From: Tom Errico <thomas.errico@tylin.com>
To: Jean Fraser <JF@portlandmaine.gov>
CC: David Margolis-Pineo <DMP@portlandmaine.gov>, Katherine Earley <KAS@port...>
Date: 6/26/2015 10:38 AM
Subject: Jewish Community Center - Final Traffic Comments

Jean - I have reviewed the revised application materials and the following represents a status update on my previous comments.

SITE PLAN

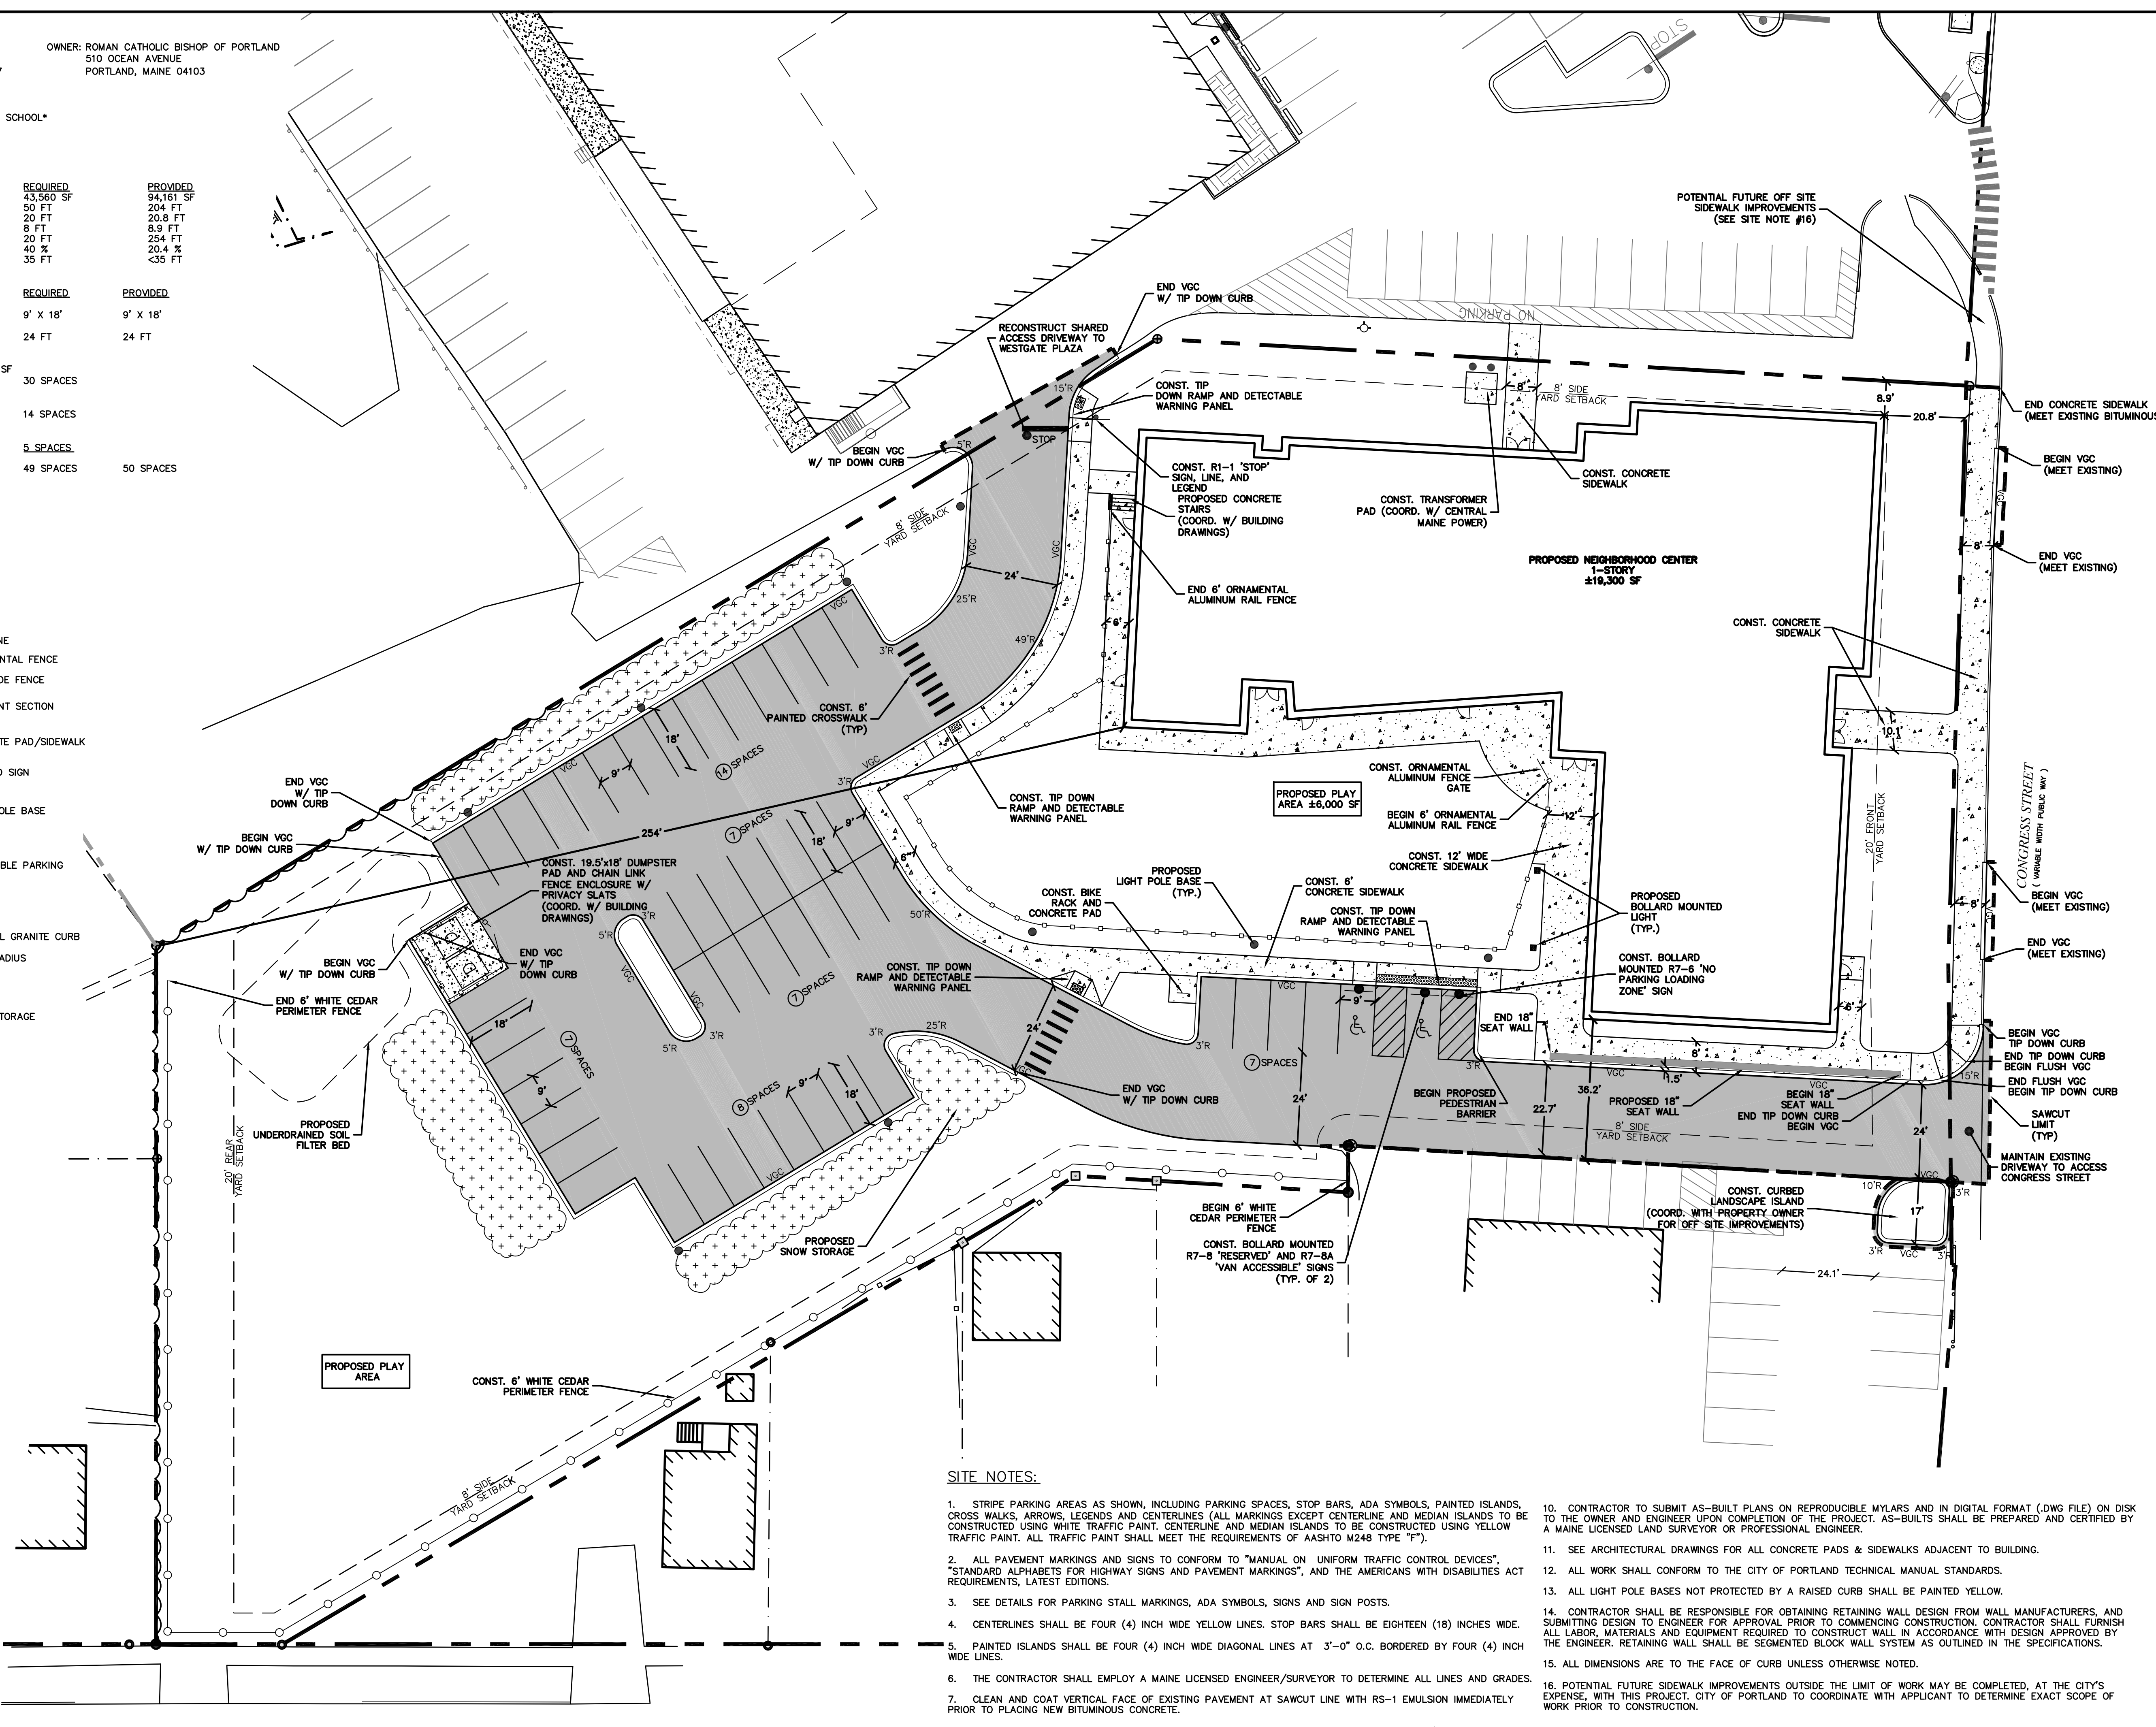
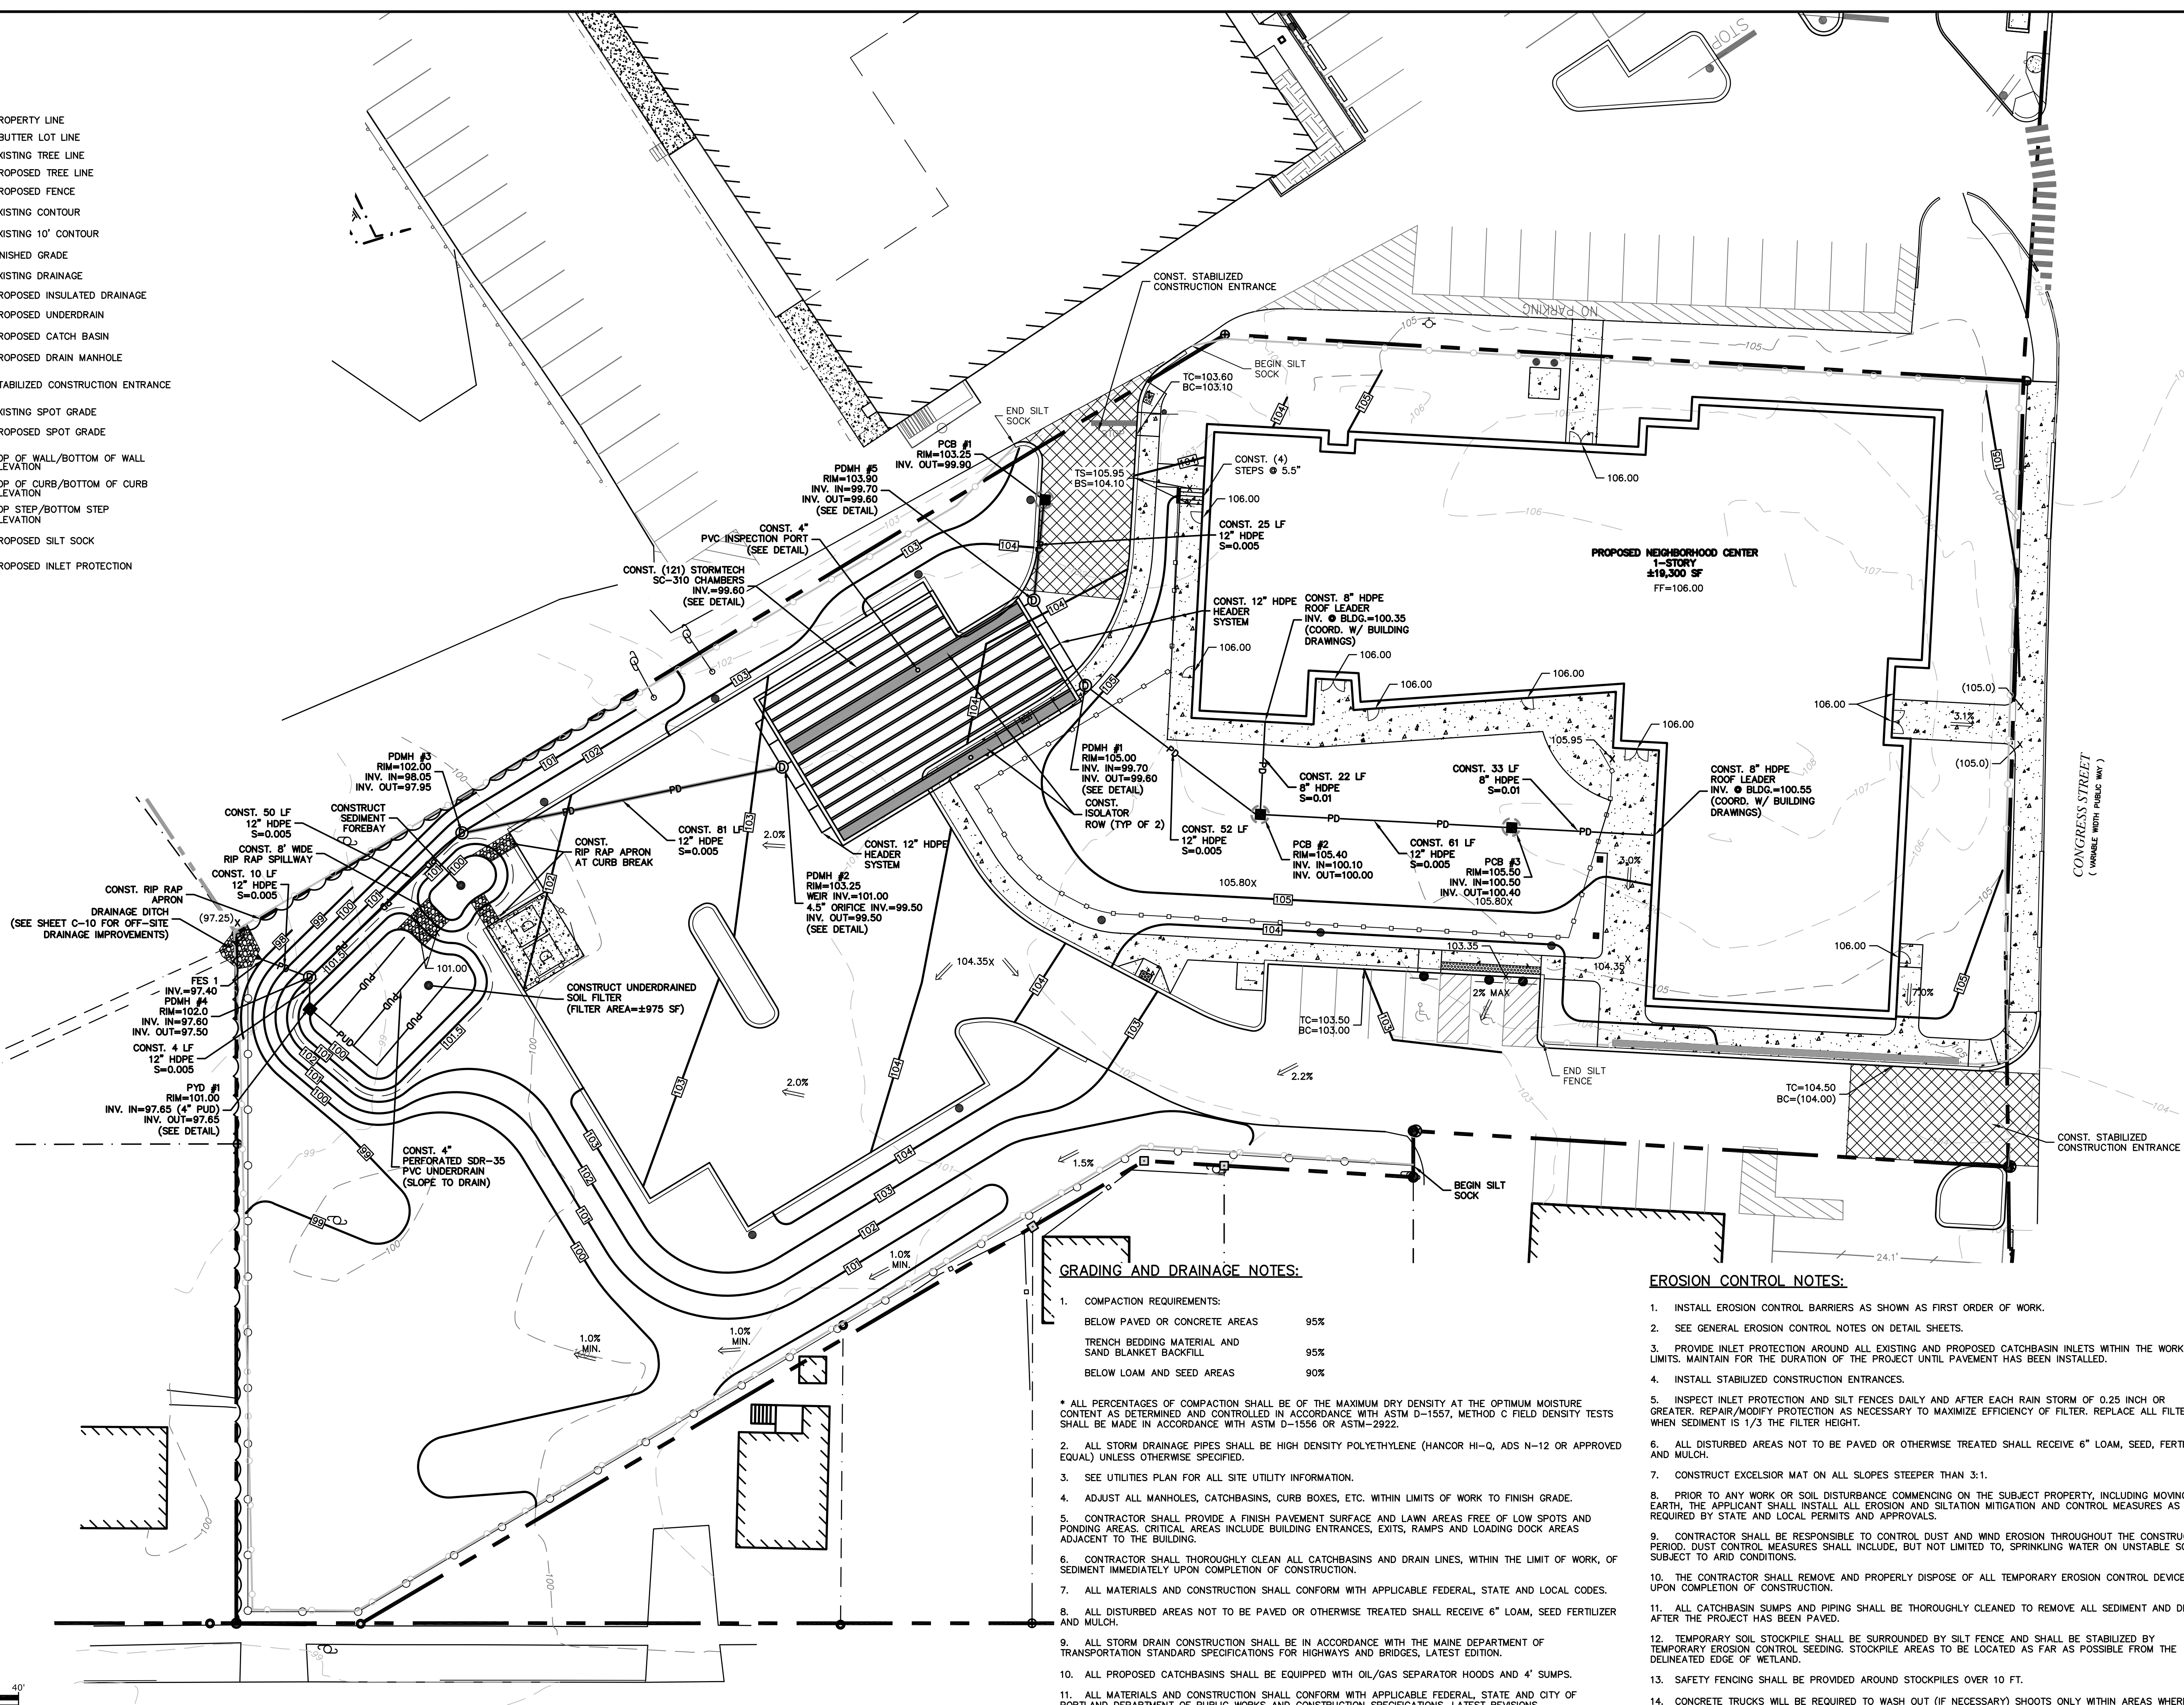
* The driveway entering the site from Congress Street is noted as having a width of 22.7 feet. This width (in the area where parking maneuvers occur) does not meet City standards and thus a formal waiver should be requested by the applicant.

* I would suggest a tip-down curb entering the driveway on Congress Street, as currently provided.

Status: The curb ramp layout should be revised so that the ramp flare does not impact accessibility along the sidewalk route. Having a tip-down design will help to address this issue.

* The applicant shall consider the formal delineation of the driveway along the medical office property boundary, when entering from Congress Street.

* The pick-up and drop-off of daycare and others will need to be carefully managed. Accordingly, the applicant should provide specific details on how this process will take place. This should include what building entrances will be used, sidewalk facilities between parking spaces and the noted entrance, etc. I would note that the pick-up/drop-off program must be managed such that vehicles are not parking along the driveway off Congress Street.

Status: I have reviewed existing JCA activity at their current Portland site and I have recommended that a barrier be constructed that prevents pedestrians from accessing the building entrance near Congress Street. The applicant has revised the site plan to include a 18" sitting wall along the curb. While the height of the wall is mountable by pedestrians, I do believe the physical presence of the wall will deter drop-off and pick-up activity near Congress Street. Accordingly, I find conditions to be acceptable.

Status: I find the proposed driveway width to be acceptable given that most vehicles will be passenger cars and that a secondary driveway via the Westgate Shopping Center will be provided. I support this waiver request.

Status: The site plan has been revised and I find conditions to be acceptable.

CONCRETE WHEELCHAIR ACCESSIBLE RAMP
NOT TO SCALE

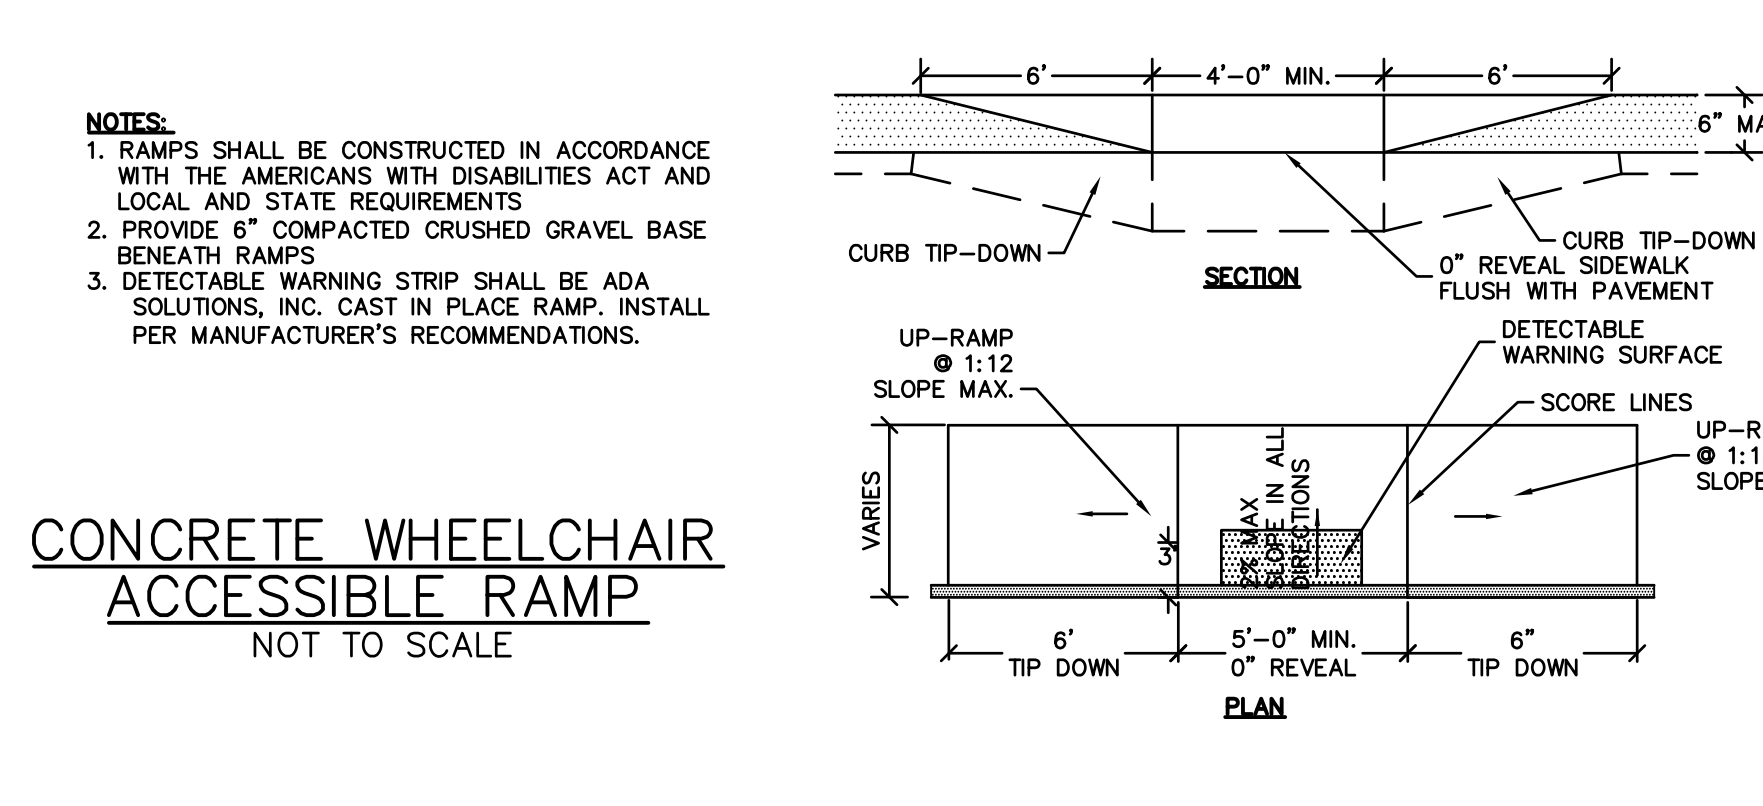
* A detectible warning panel is not required at the site driveway on Congress Street.

Status: The plans have been revised and I have no further comment.
